# CITY OF ALBUQUERQUE

**RE: 3409 Herrera Rd. NW  
3409 Herrera Rd. NW  
Grading and Drainage Plan  
Engineer's Stamp Date: 2/4/22  
Hydrology File: F17D026A**

Based upon the information provided in your submittal received 2/4/22, the Grading & Drainage Plan **is not** approved for Building Permit. The following comments need to be addressed for approval of the above referenced project:

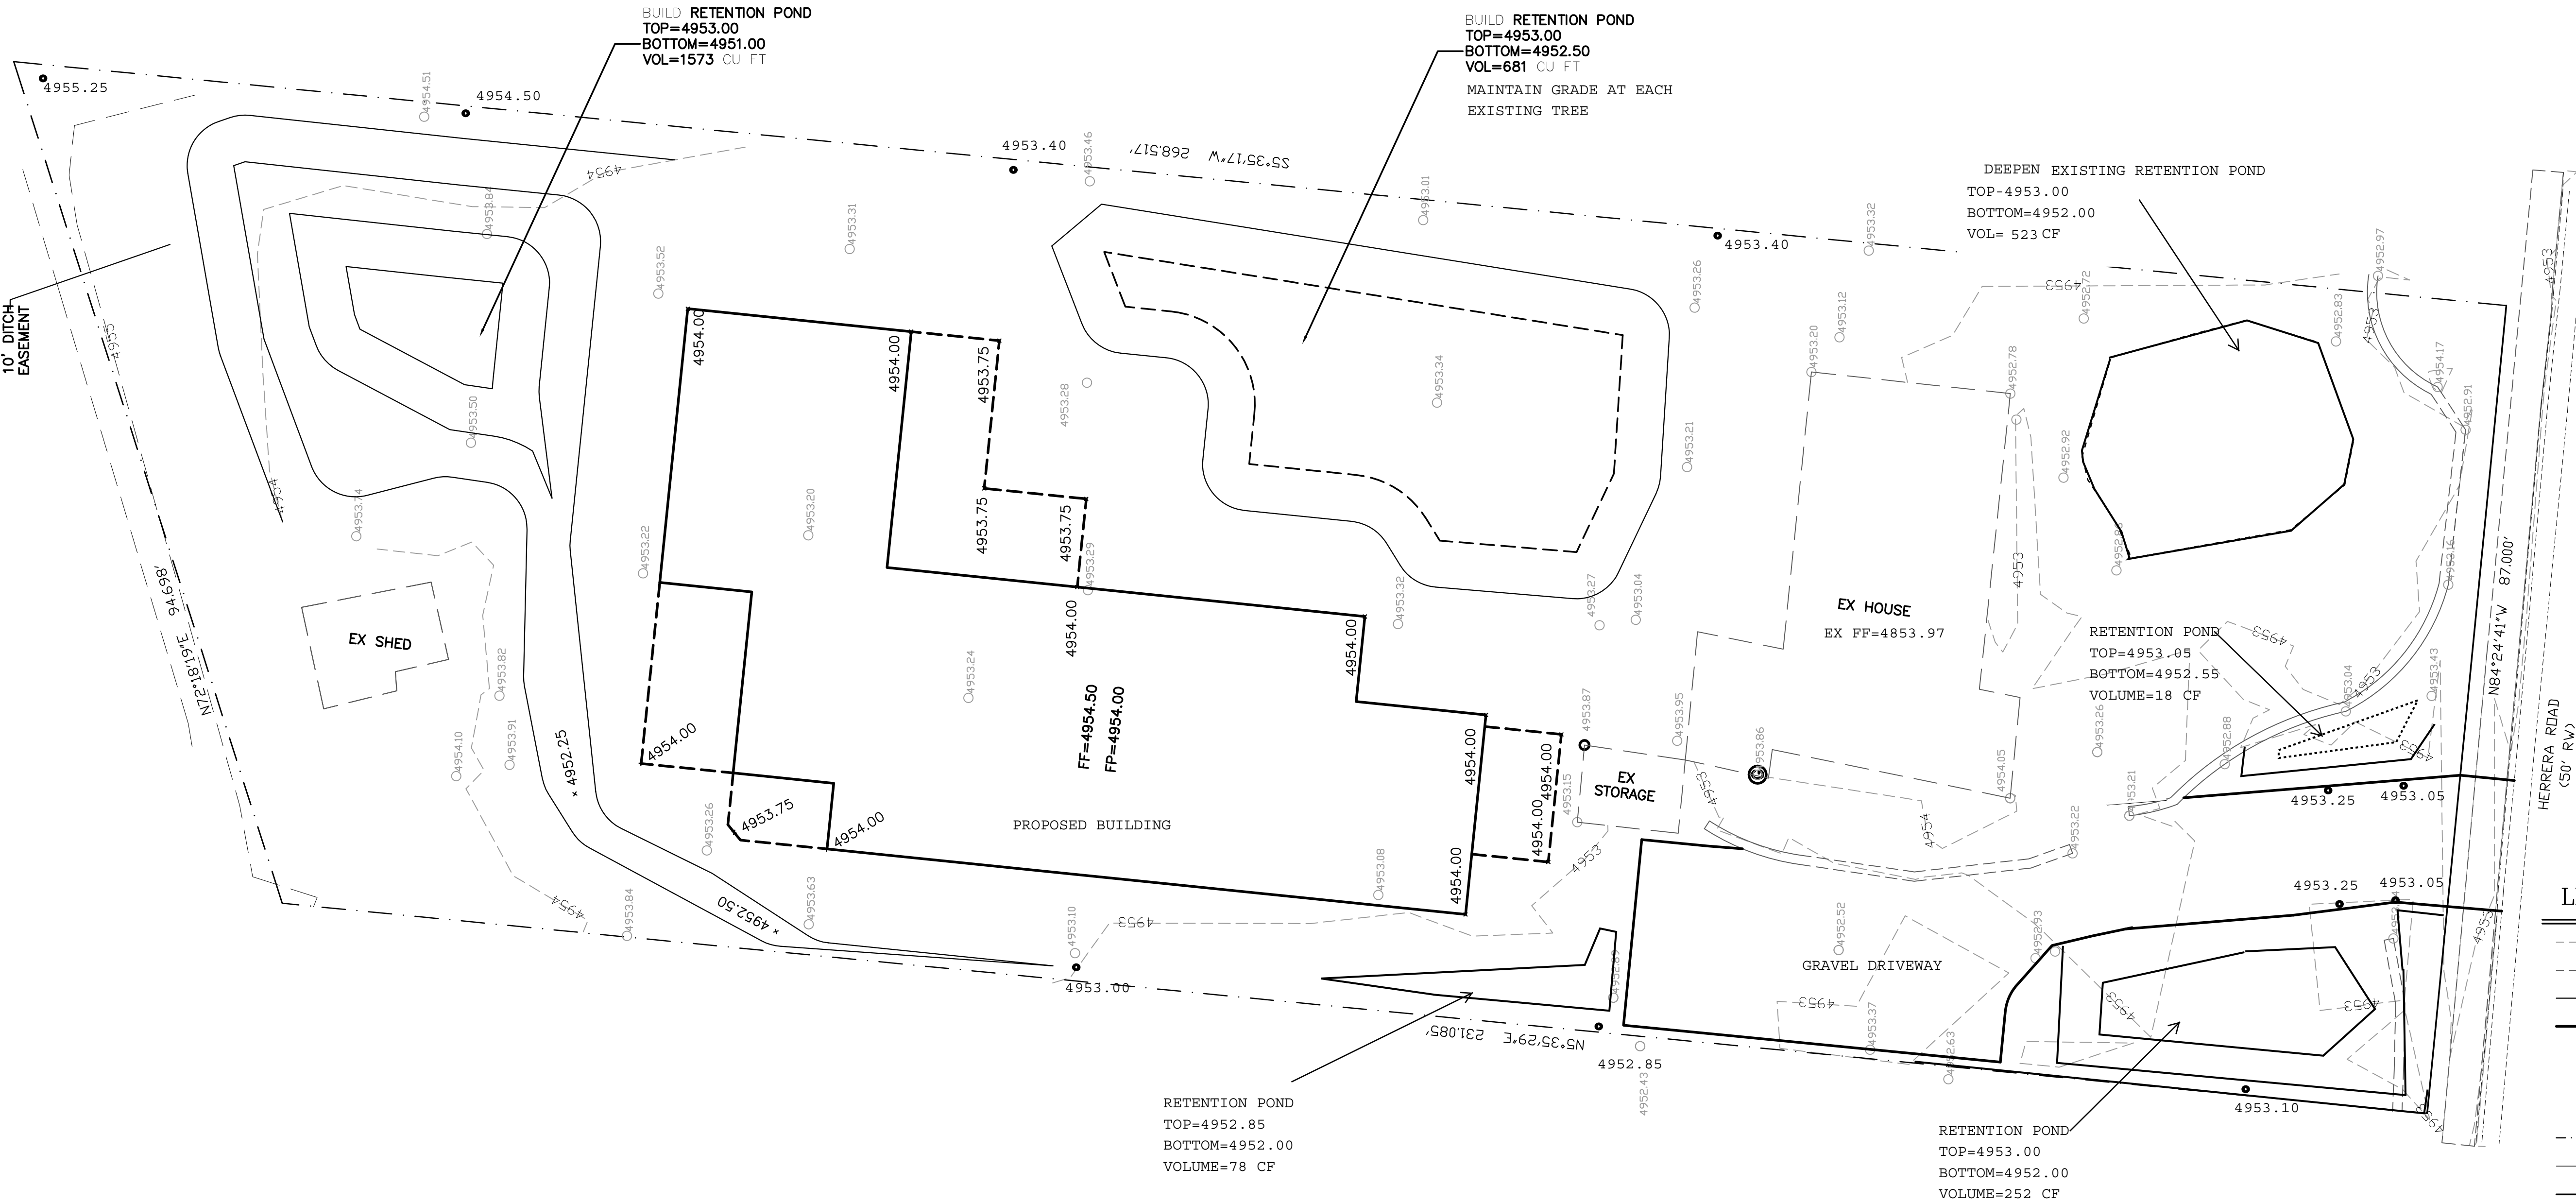
1. Please review the calculations. I do not see where you came up with the 4690 cf of volume. One pond is 1573, one 681 and existing 185 as shown on the plans. That adds up to 2439 cf.
2. Please update as no first flush is required for residential.
3. Please enlarge the text for the calculations and summary/narrative.
4. Would it make sense to connect the ponds and allow discharge out to the roadway. Should these be detention ponds? For retention, please calculate the 10 day volume for the 100 year storm and provide that storage.
  - a. For retention, the site must collect all of the flow.
5. Please show enough points to ensure no flow will go to neighboring sites. Driveway area is not clear.
